**SSD-14540514: Wallerawang Battery Energy Storage System Response to Submissions (RtS)**

Thank you for the above referral via the NSW Major Projects Portal on 4 May 2022 inviting comment from Transport for NSW (TfNSW) as a part of the RtS for the Wallerawang Battery Energy Storage System (BESS) proposal.

TfNSW has reviewed the RtS and is supportive of the proposal proceeding subject to conditions. Pursuant to section 138(2) of the *Roads Act 1993*, TfNSW is willing to grant its concurrence subject to the following conditions being met:

Figure 4-1 Rural access requirements

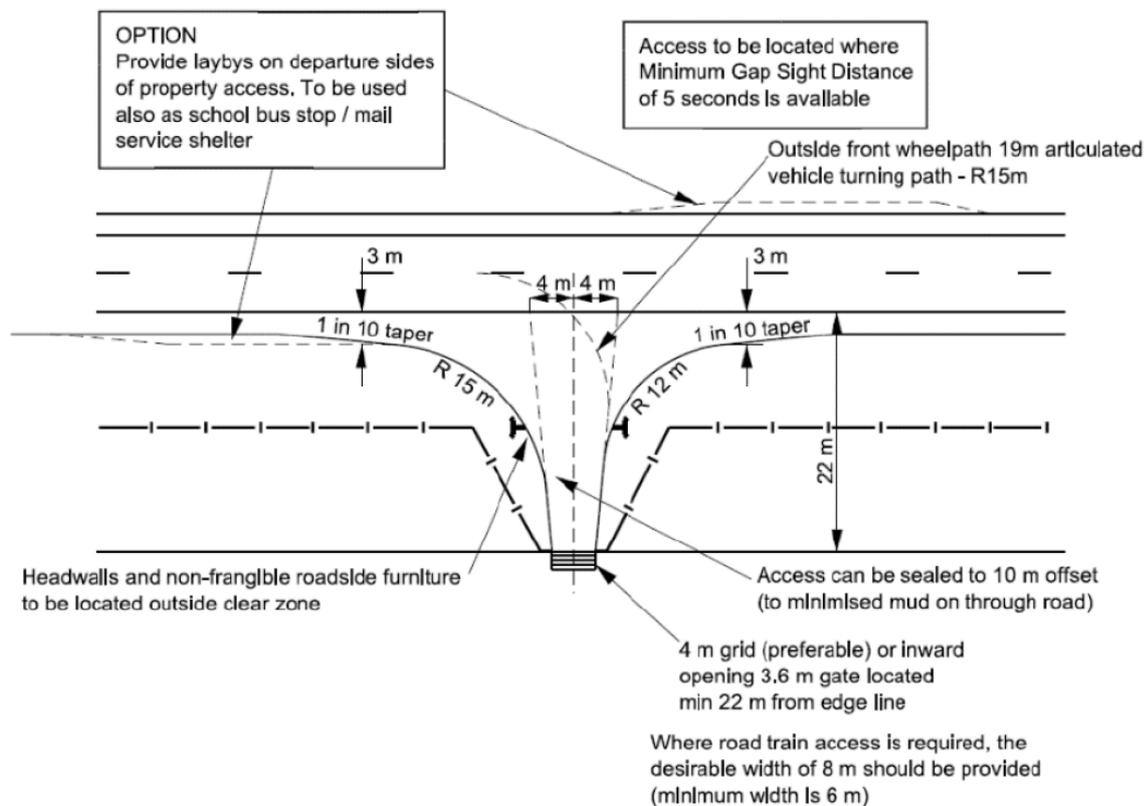
- A Basic Right (BAR) turn treatment as shown in Figure 7.5 Part 4A of the *Austroads Guide to Road Design* on the Castlereagh Highway. The widened shoulder is to be sealed and built for an 100km/h speed environment to provide a reasonable level of safety for vehicles turning right into the access and to allow following vehicles an area to pass the right turning vehicle on the left hand side.

- A Rural Auxiliary Left Turn Treatment – Short Turn Lane [AUL(S)] on the Castlereagh Highway generally in accordance with Figure 8.3 Part 4A of *Austroads Guide to Road Design* and relevant TfNSW supplements.

Figure 4-5 Concept of Safe Intersection Sight Distance (SISD)

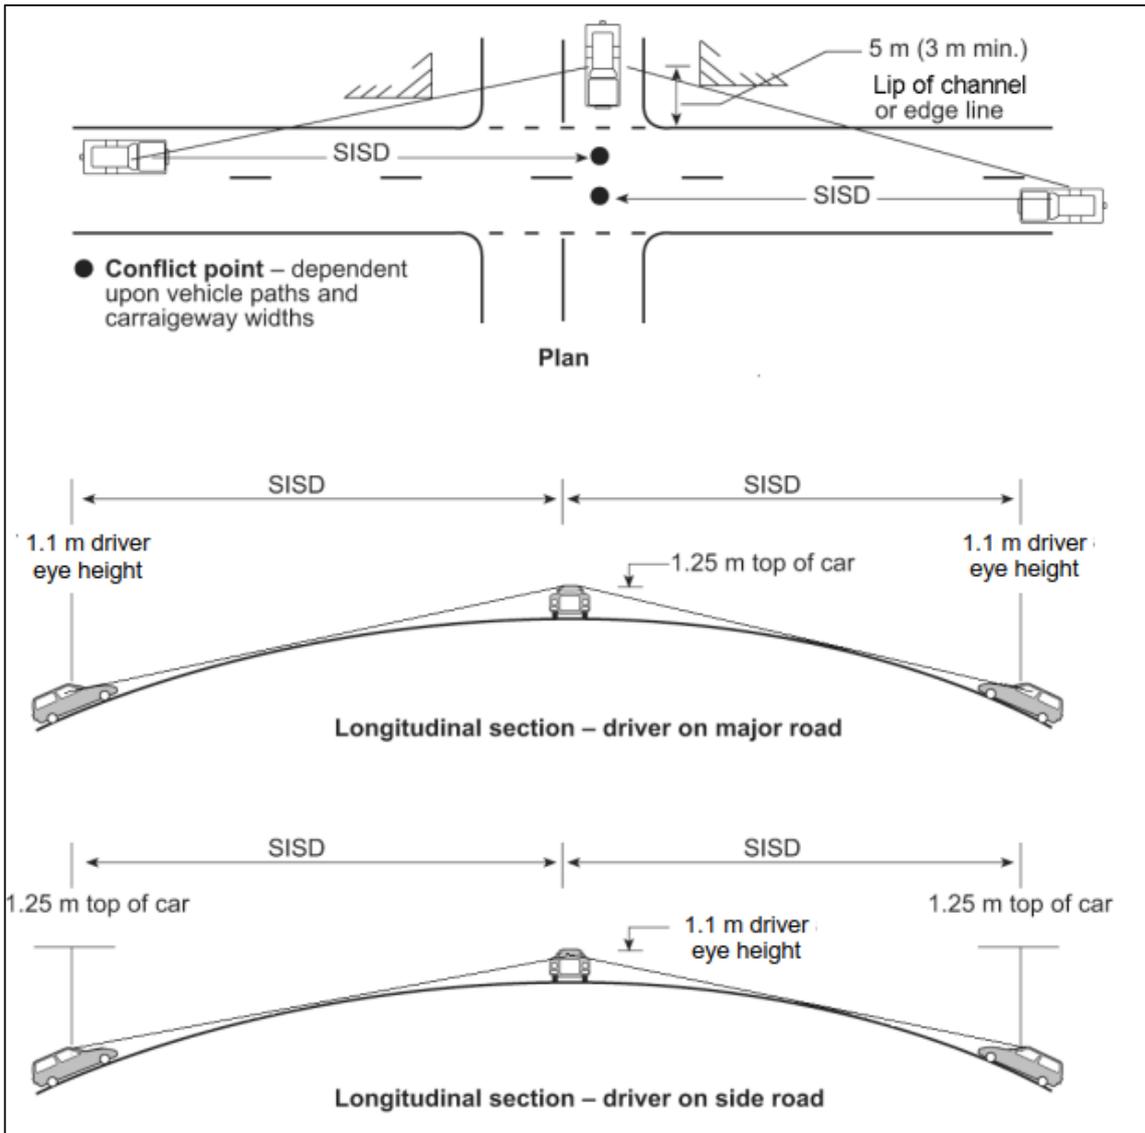
- Safe Intersection Sight Distance (SISD) requirements outlined in the *Austroads Guide to Road Design* Part 4A and relevant TfNSW supplements is to be provided and maintained at the site access to the Castlereagh Highway. For a 100 km/h speed zone the minimum SISD is 262 metres.
